Please ask for: Mrs D Johnson
Email: daun.johnson@arun.gov.uk
Telephone: 01903 737762
Our Ref: LU/124/21/PL
Your Ref:
Date: 6th May 2021

Application for Planning Permission

Development: Change of use from C2 Residential Institution to HMO (Sui Generis). This site may affect the setting of listed buildings & affects the character & appearance of the East Street, Littlehampton Conservation Area.
Location: 18-22 East Street Littlehampton BN17 6AW

Drawing Title
Existing Floor Plans and Elevations (18-20)

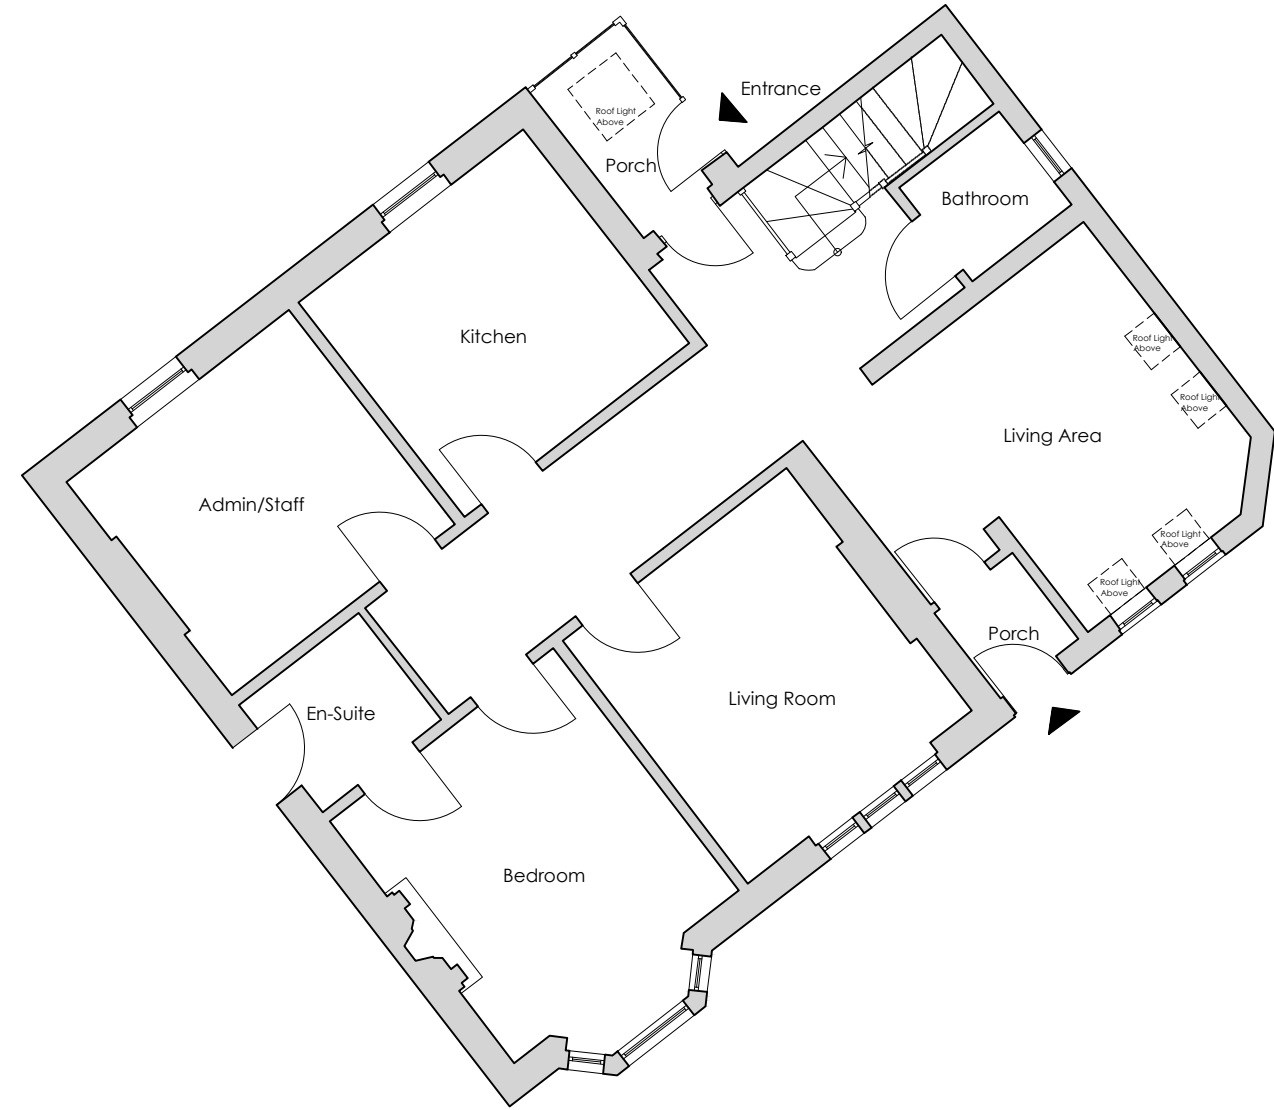
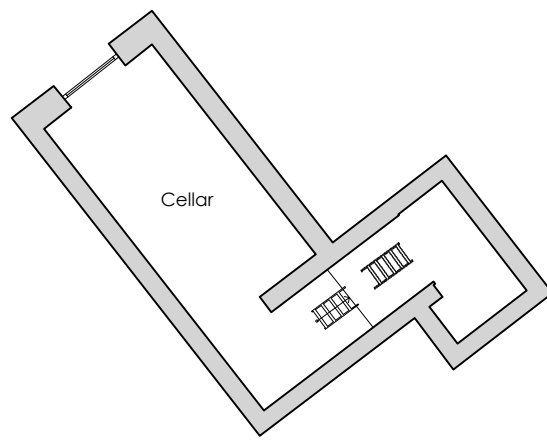
The existing and proposed floor plans and West elevation on 18-20 East Street do not accord. Please amend accordingly.
